PLAN:
Hayek

APPROVED
Limited building only review
Parent holder responsible for full compliance with the code

PROJECT ADDRESS:
TBD Sears Dr. (Lot 27)

FRONT ELEVATION

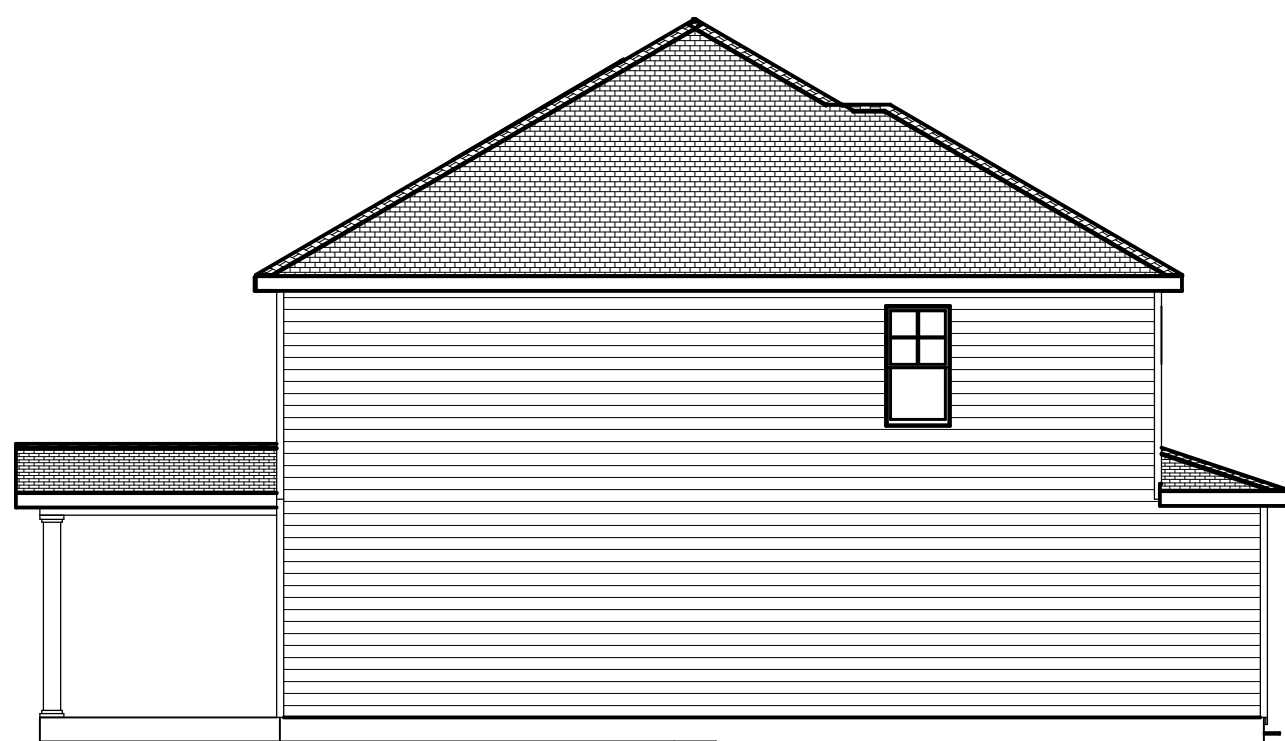
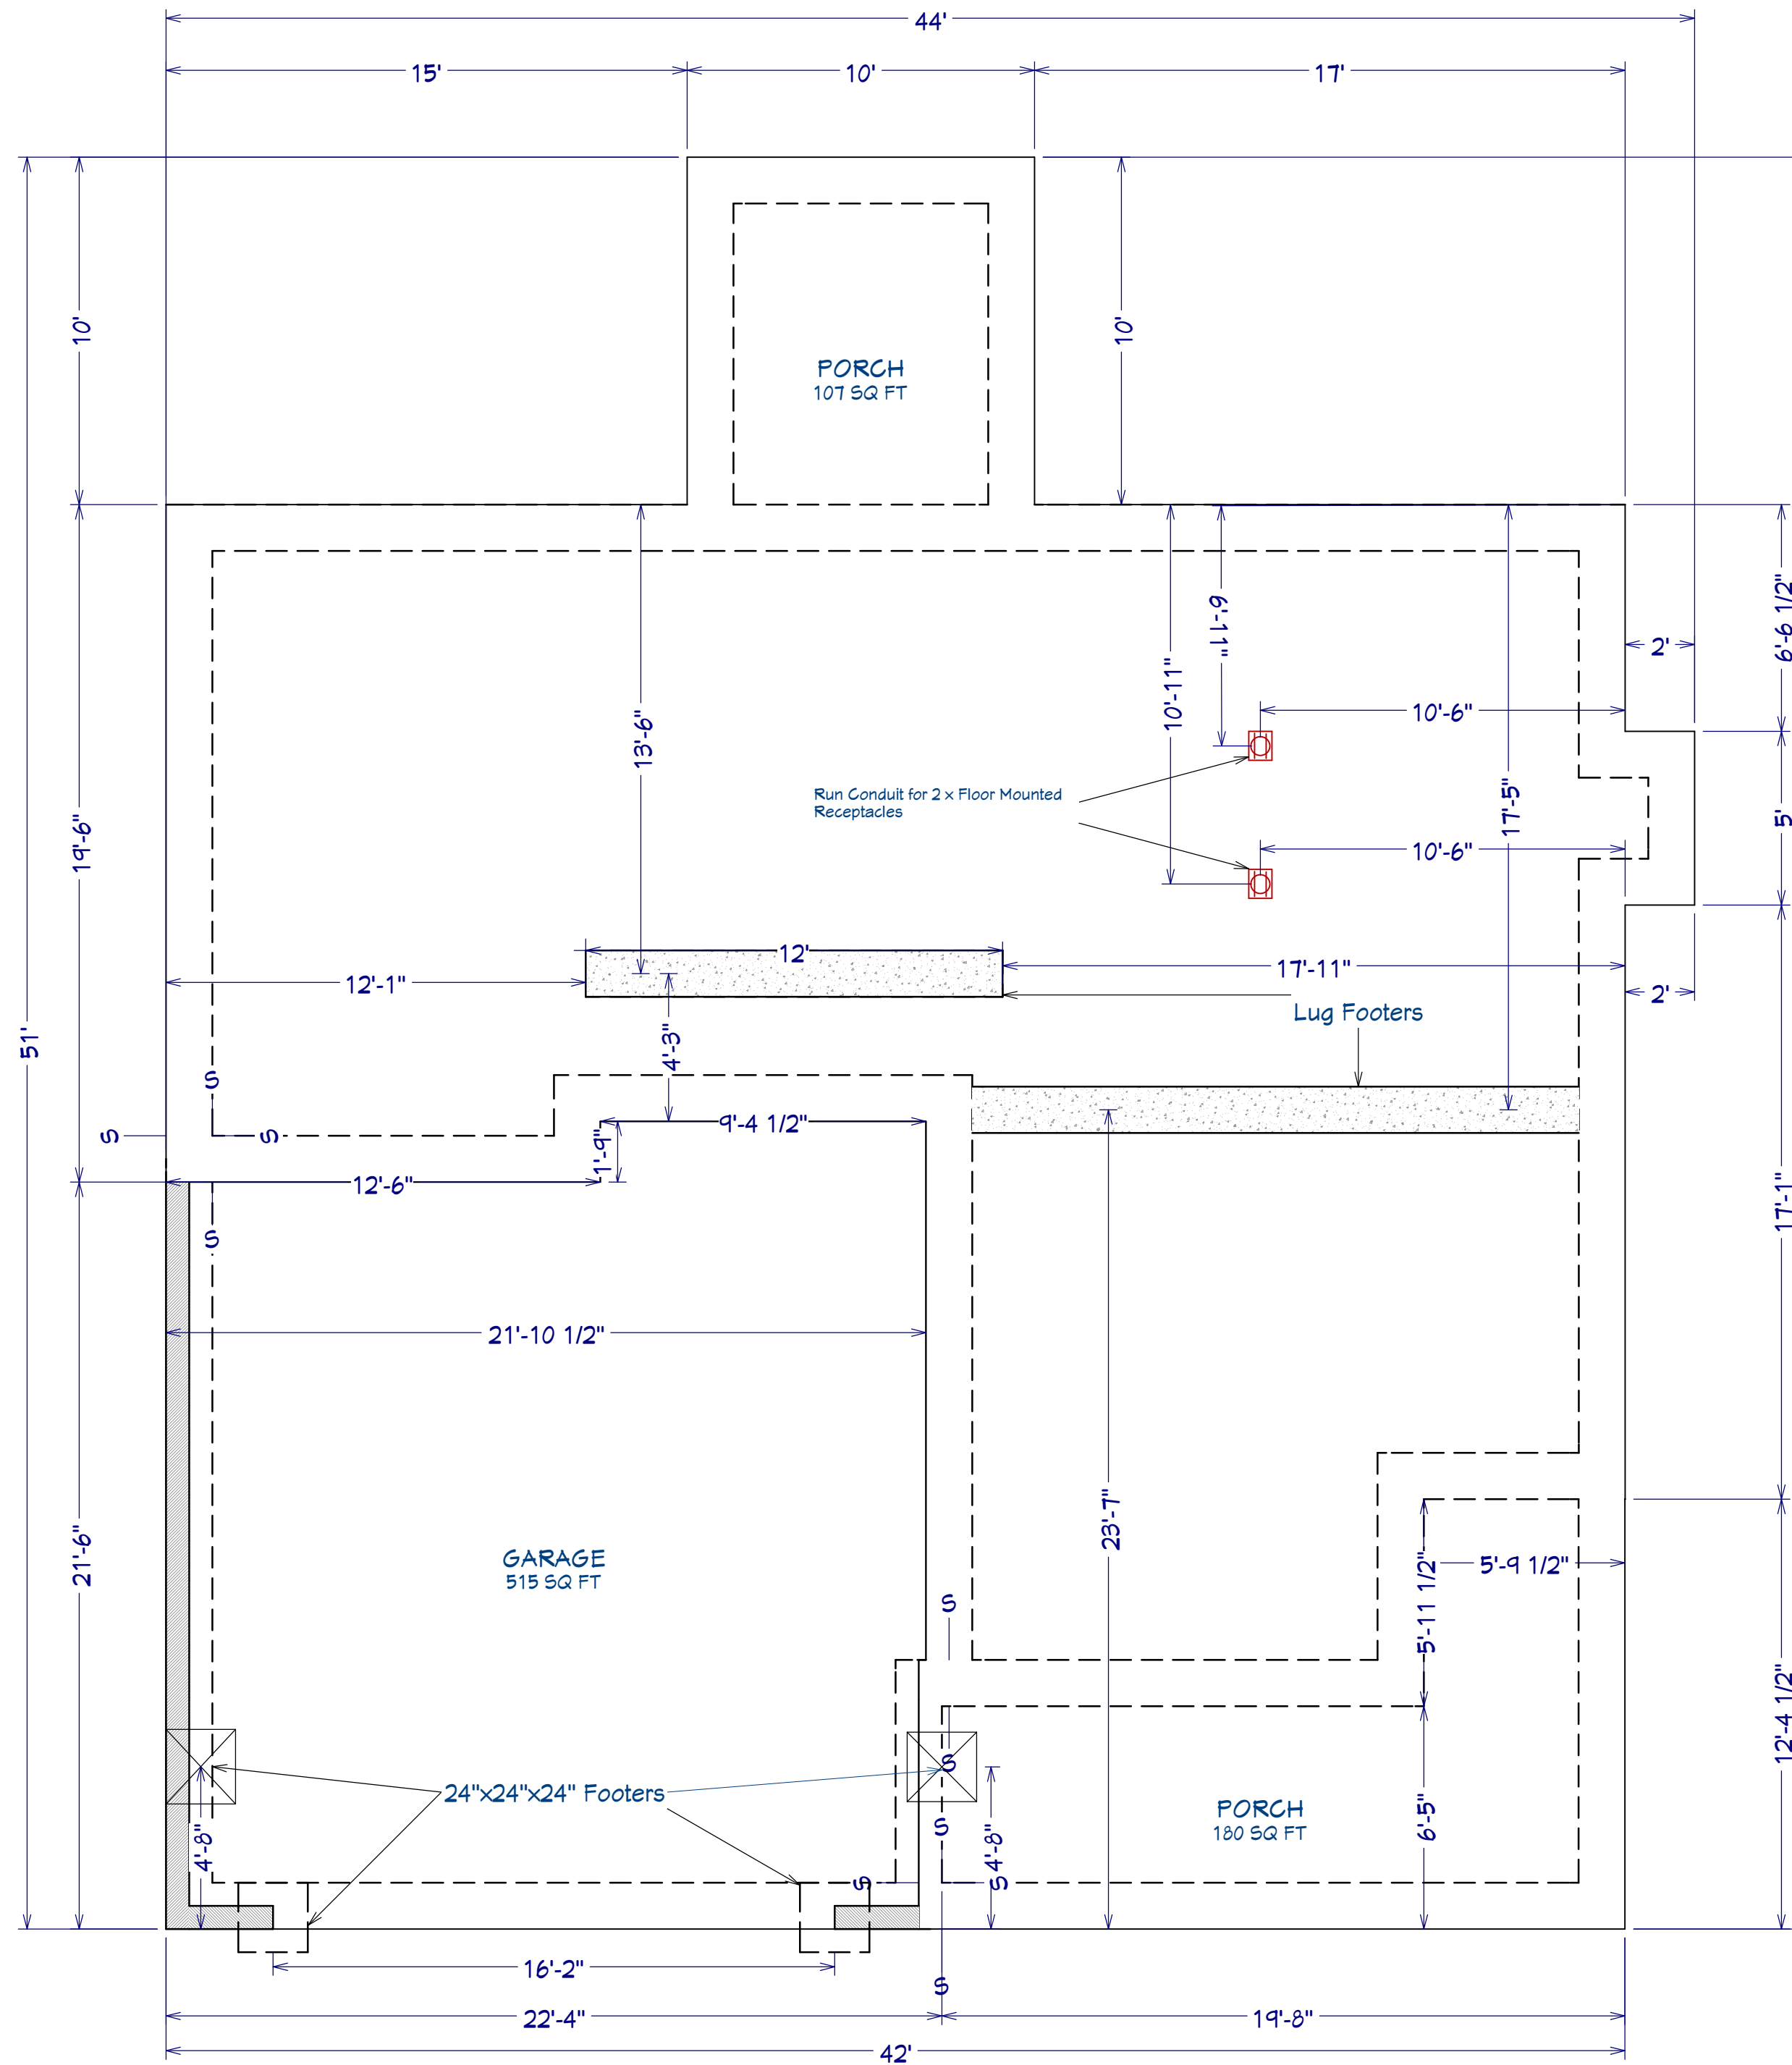
All exterior walls must be 2x6 per energy design
